Two storey rear and side extension. Removal of existing conservatory and replacement with single storey childrens room (also at rear). Enlargement of attached garage at front. Removal of mock Georgian portico at front and construction of matching enclosed porch
65 Golden Avenue East Preston

Thank you for your internet comments made on 4th October 2012 and recorded as follows:

Drawing Title
FIRST FLOOR PLAN
and
CROSS SECTIONS

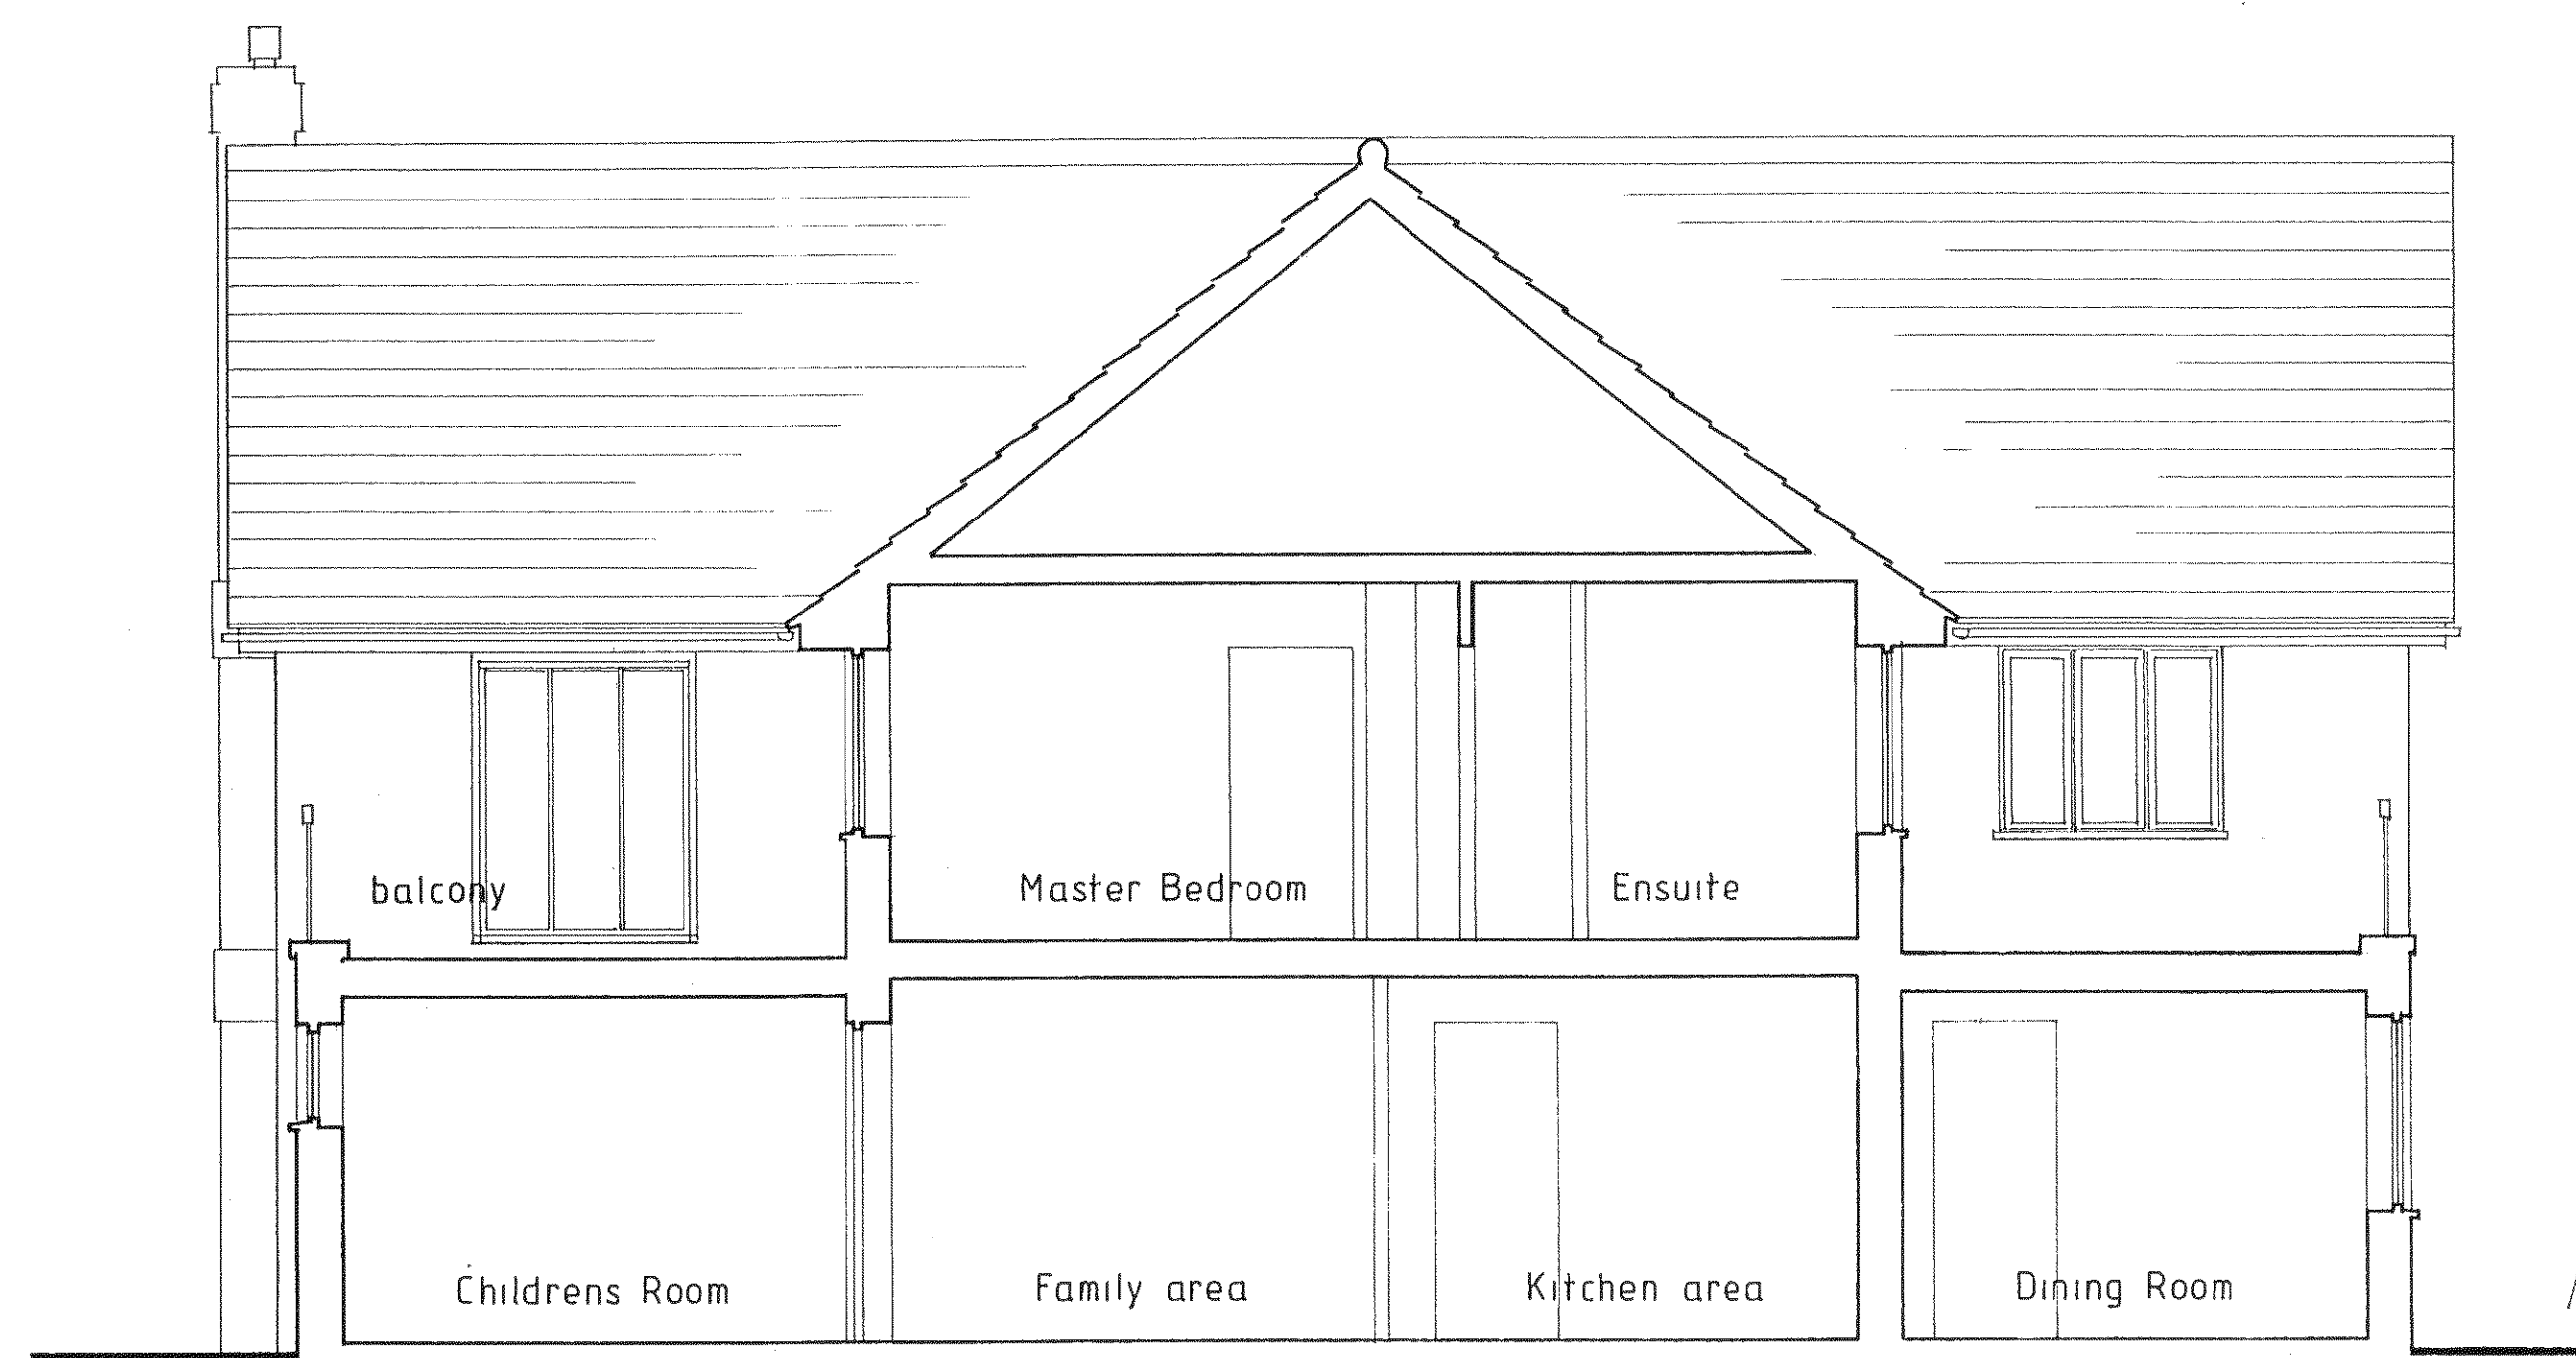
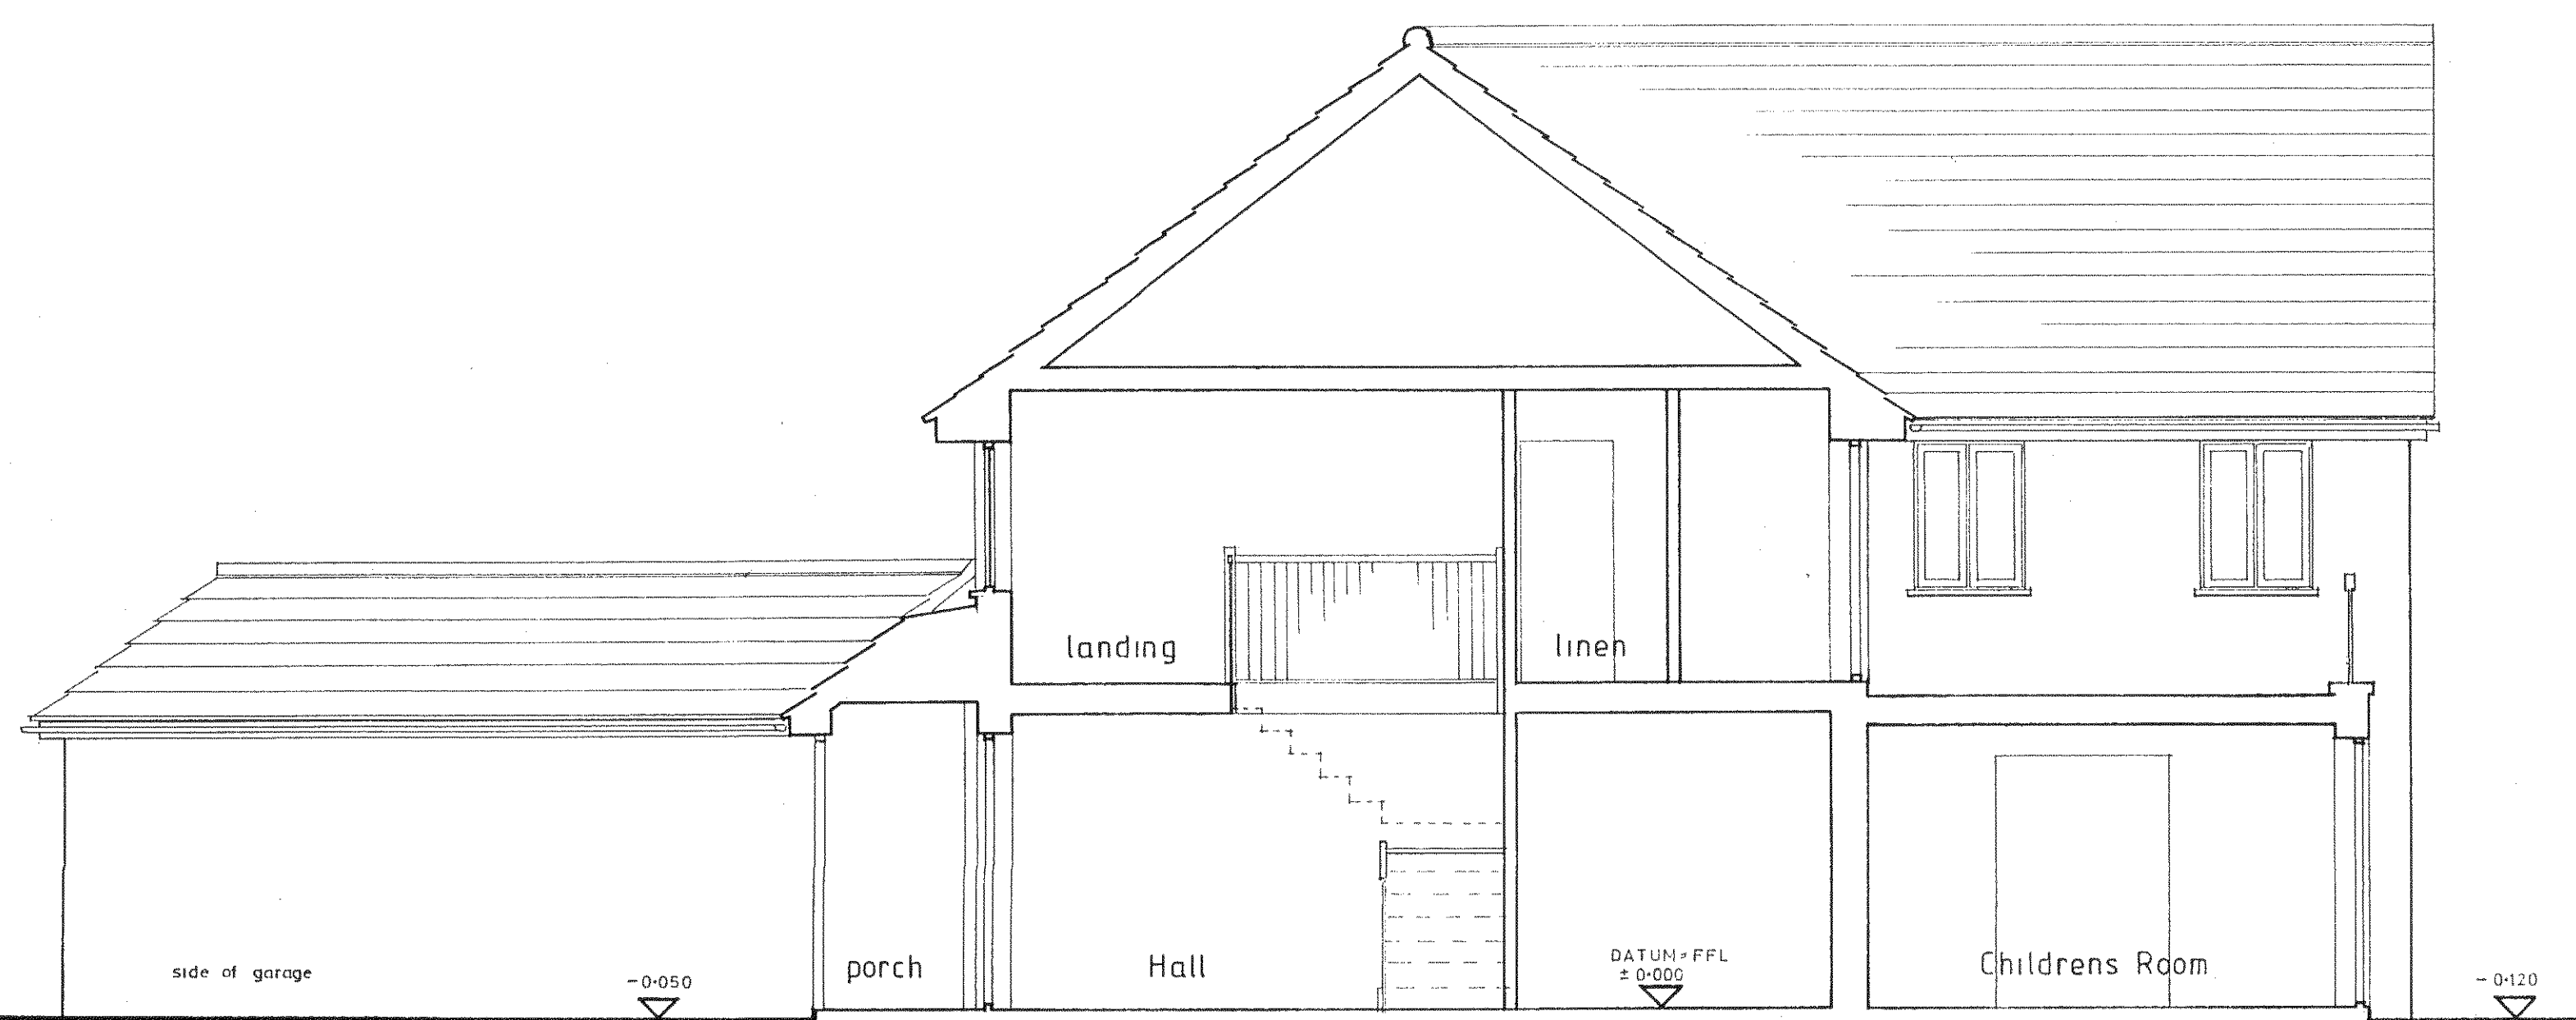
Council objects to the application considering that the rear first floor extension windows and balcony will be intrusive to neighbouring properties, particularly to the south of the property. Council considers:

- 1) there should be obscure glass in the new first floor bedroom windows facing south*
- 2) there should be a privacy screen fitted to the southern end of the new proposed balcony. (Council accepts that this might negate the need for obscure glass in the most westerly of the new first floor bedroom windows facing south referred to above & but it is unclear from the drawings supplied).*
- 3) there should be obscure glass in the north facing window of the new en suite bathroom.*
- 4) there should be a condition preventing access to the flat roof over the dining room except for repairs and maintenance.*
